ADDENDUM

Re Addendum No. 3 to the Bidding Documents for:

USM
Central Heat Plant Upgrades
Portland, ME
Project No. 14411

A81.1

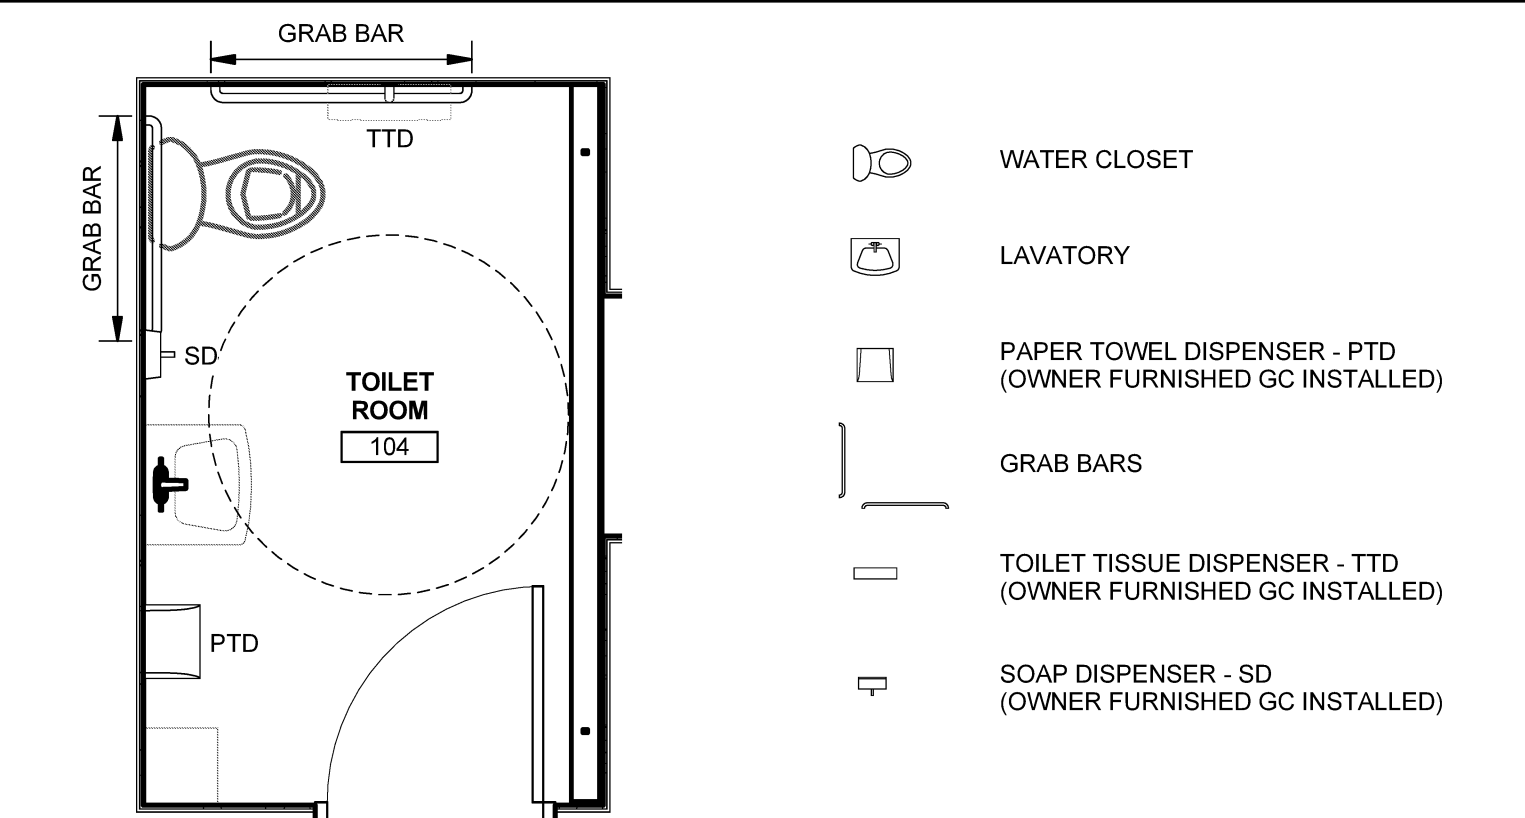
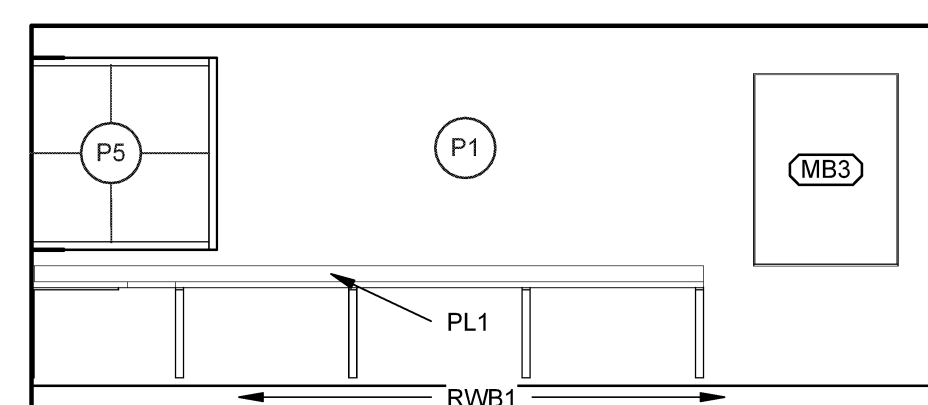
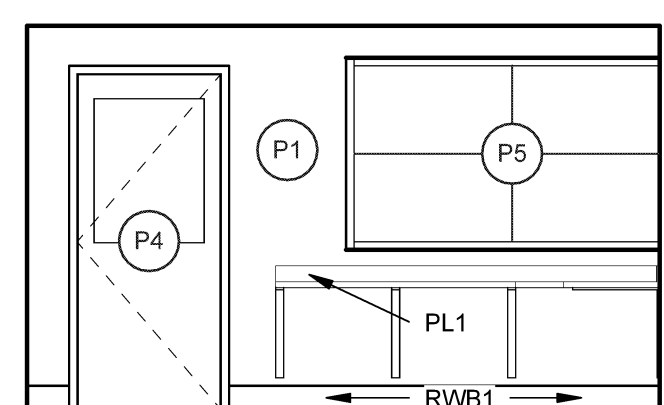
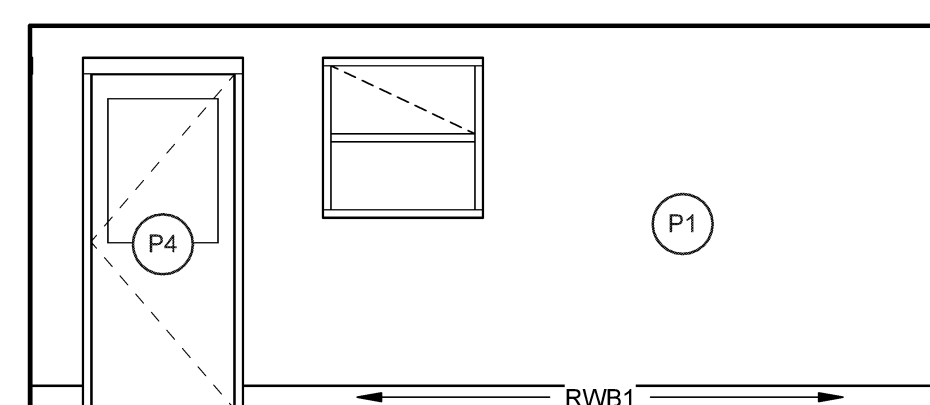
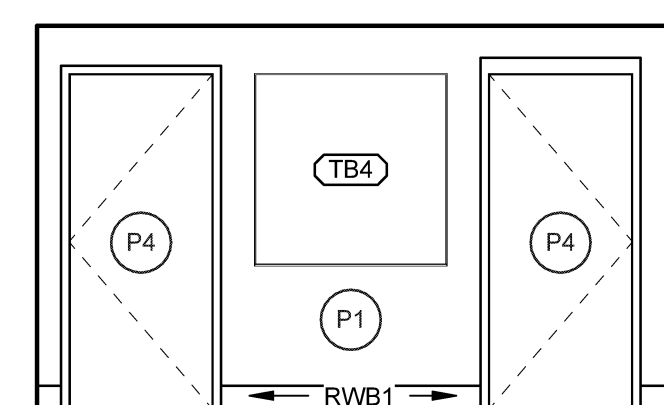
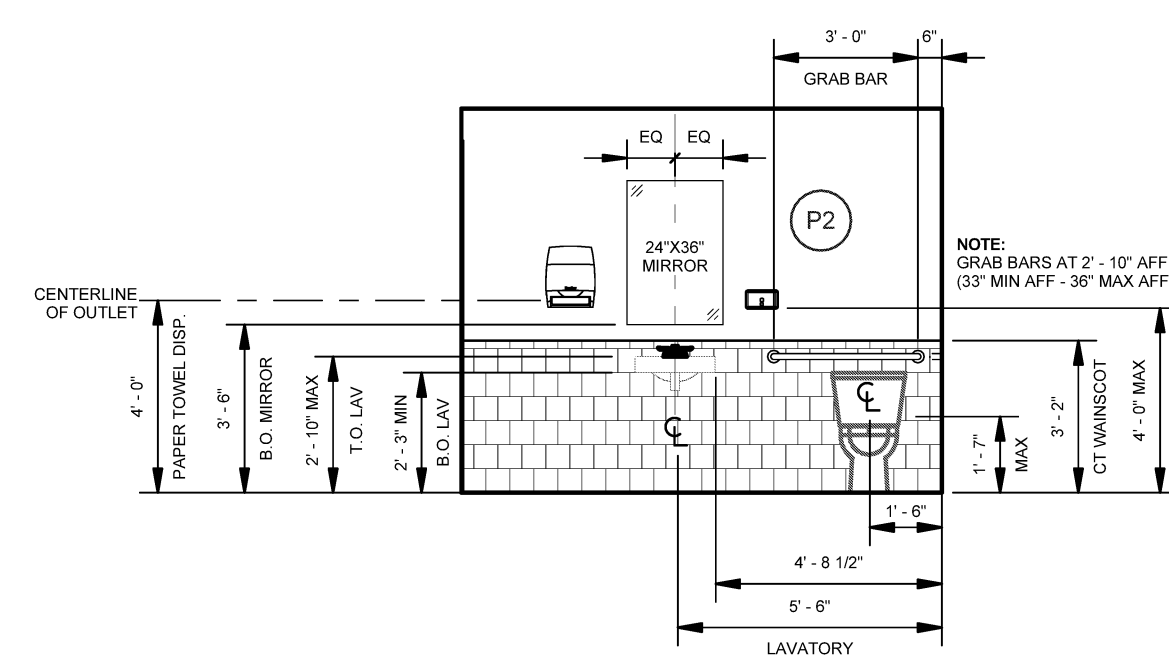
1. DRAWING A40.1 – CONSTRUCTION SYSTEMS AND DETAILS
 - a. Partition type W01
 - 1) Change note that reads “Weather Barrier Membrane” to read “Air/Vapor Barrier Membrane”
 - b. Details C1, C5, D2, D3:
 - 1) Change note that reads “Pre-Finished Metal Enclosure” to read “Aluminum Break Metal By Storefront Manufacturer”
 - c. Details E1, E2, E3, D1:
 - 1) Change note that reads “Pre-Finished Metal Enclosure” to read “Pre-Finished Metal Trim”
2. DRAWING A55.1 – DOOR AND WINDOW SCHEDULES
 - a. Detail D1:
 - 1) Door type S, graphically remove horizontal lines indicating an overhead door.
3. DRAWING A81.1 – INTERIOR ELEVATIONS
 - a. Paint Schedule:

- 1) Remove “Duration Ext. Acrylic Coat” from description of paints labeled P1, P2, P3, P4, P5, P6
- 2) Add general note: “See specifications for product requirements.”
